**STATE SIGNIFICANT DEVELOPMENT:
Section 96(1A) Modification Application**

AUSTRALIAN TECHNOLOGY PARK, EVELEIGH

SSD 7317 MOD 3

Environmental Assessment Report
Section 96(1A) of the *Environmental Planning
and Assessment Act 1979*

1 DA SECTION A-A (NORTH SOUTH)
1 : 125

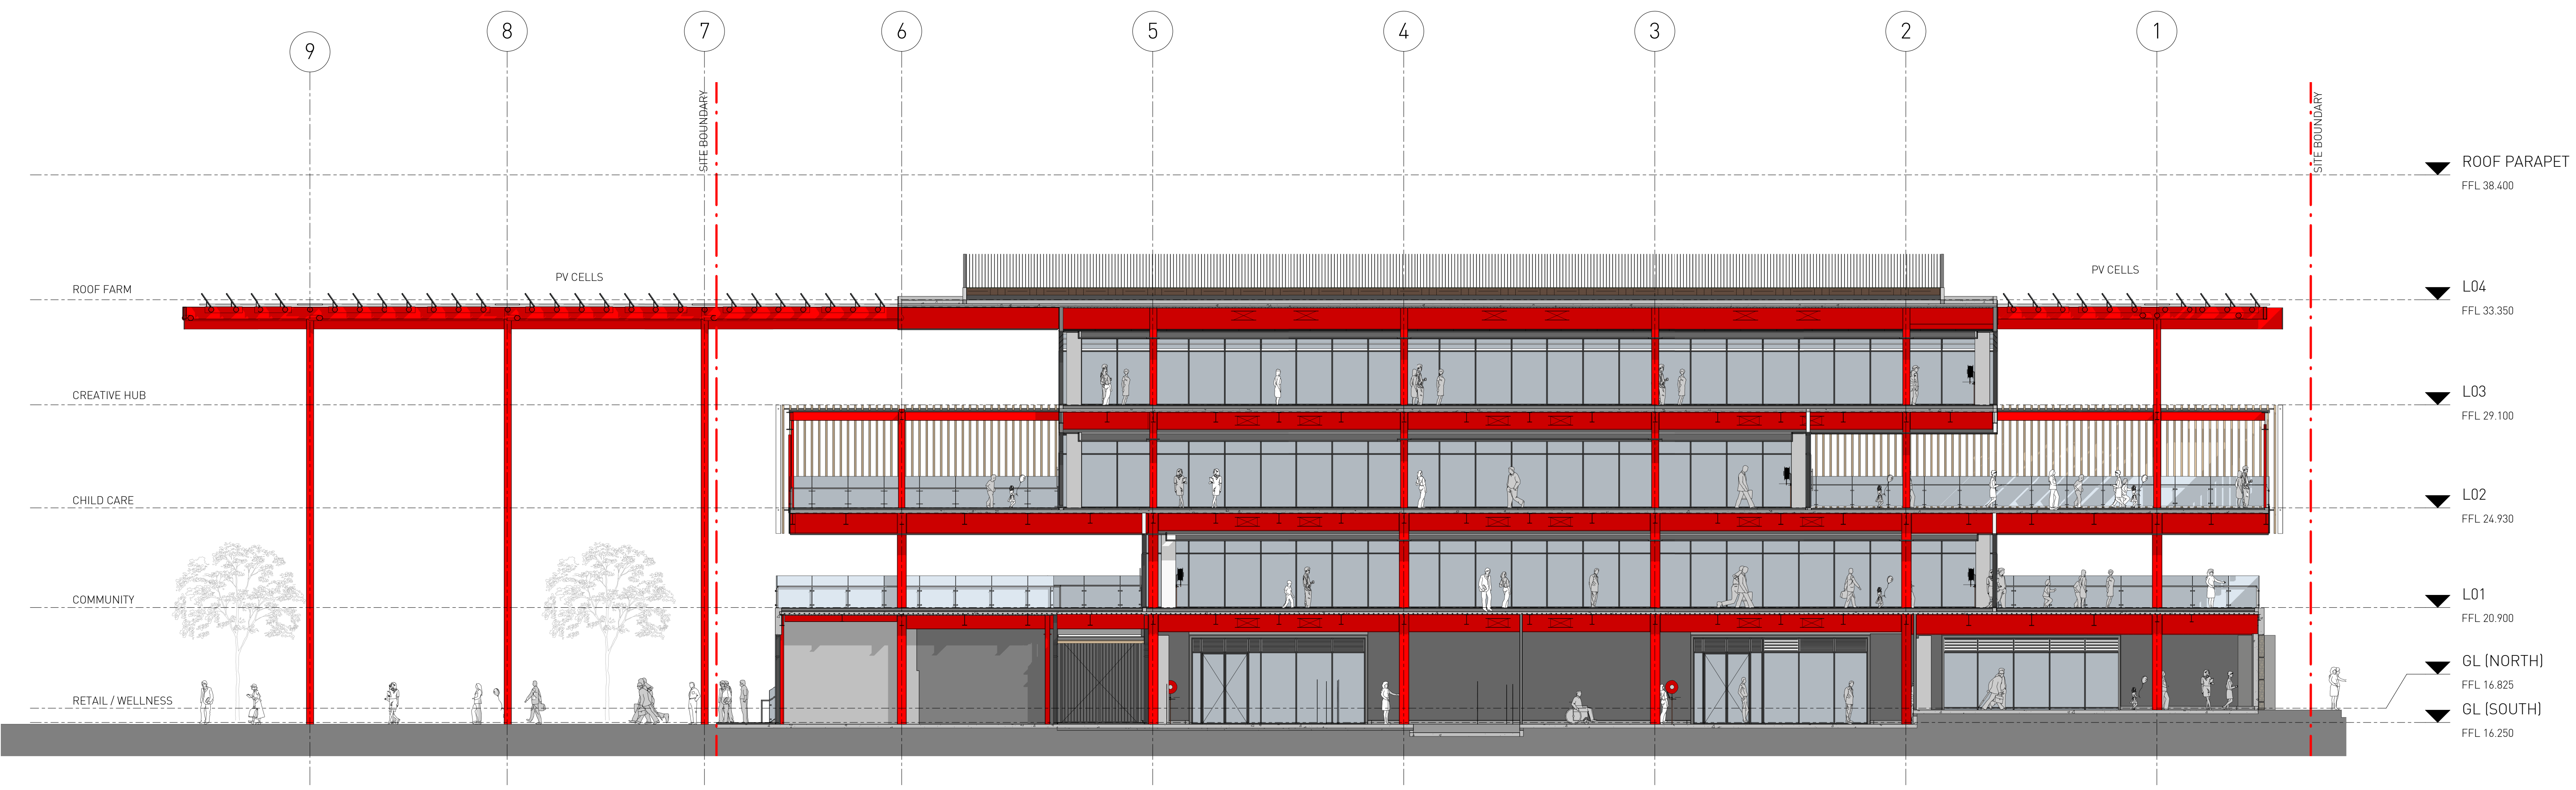
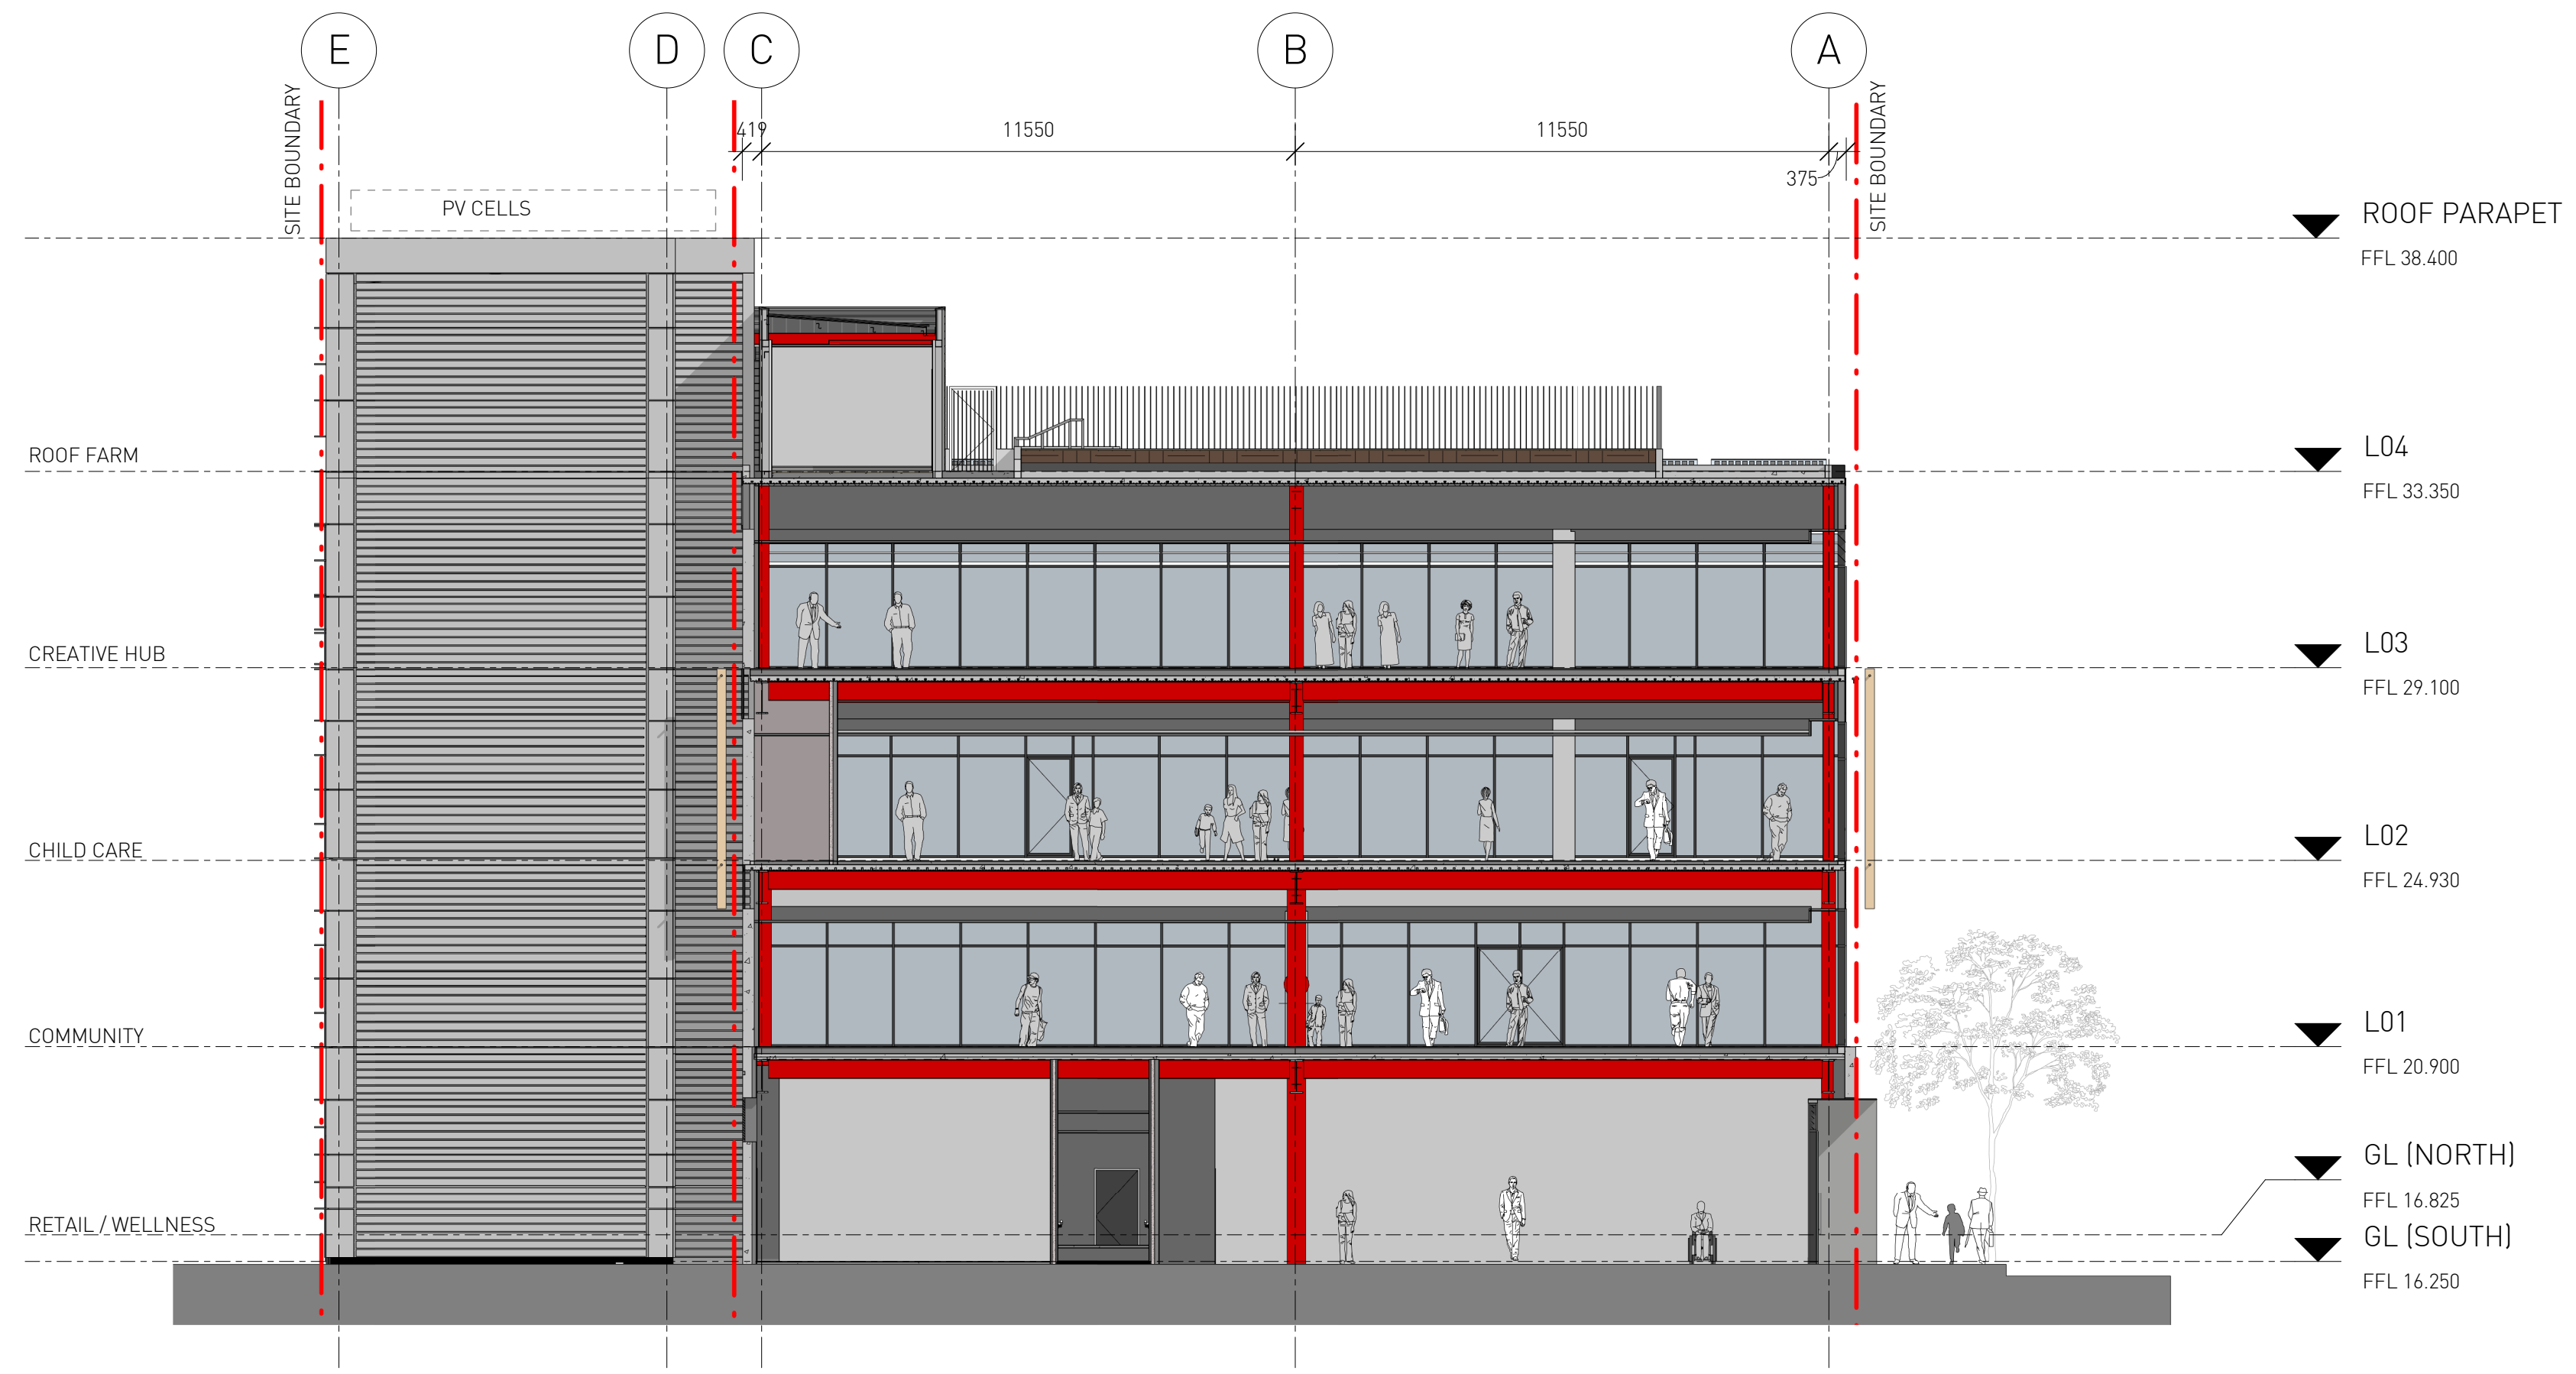
The proposal seeks to redesign the roof canopy and in doing so increase its length from 16.25 metres to 24.5 metres measured from the southernmost edge of the building (**Figure 6**). The Applicant is proposing a lightweight steel canopy with PV cells that act as louvres, allowing sunlight to come through to the public domain area below, compared to the approved roof which shades the public domain area.

Council does not support the proposed amended roof canopy and considers the approved design provides an elegant sculptural quality to the building as well as greater visual interest. Council also raised concern about the greater extent of the proposed roof canopy compared to what has previously been approved.

The Department has considered Council's concerns about the roof canopy and considers that while the canopy is longer, it is acceptable for the following reasons:

- the industrial architectural style is appropriate to the precinct
- the proposed design will allow sunlight to the area below and also be finished in white/silver which will offset the perception that it is heavier and bulkier than that previously approved
- the extended rooftop canopy will provide additional weather protection to the open space area and will create a sense of place and contribute to the activation of the south, southeast and southwest of the building
- the use of PV cells on the roof canopy contributes to the energy efficiency of the building perspectives
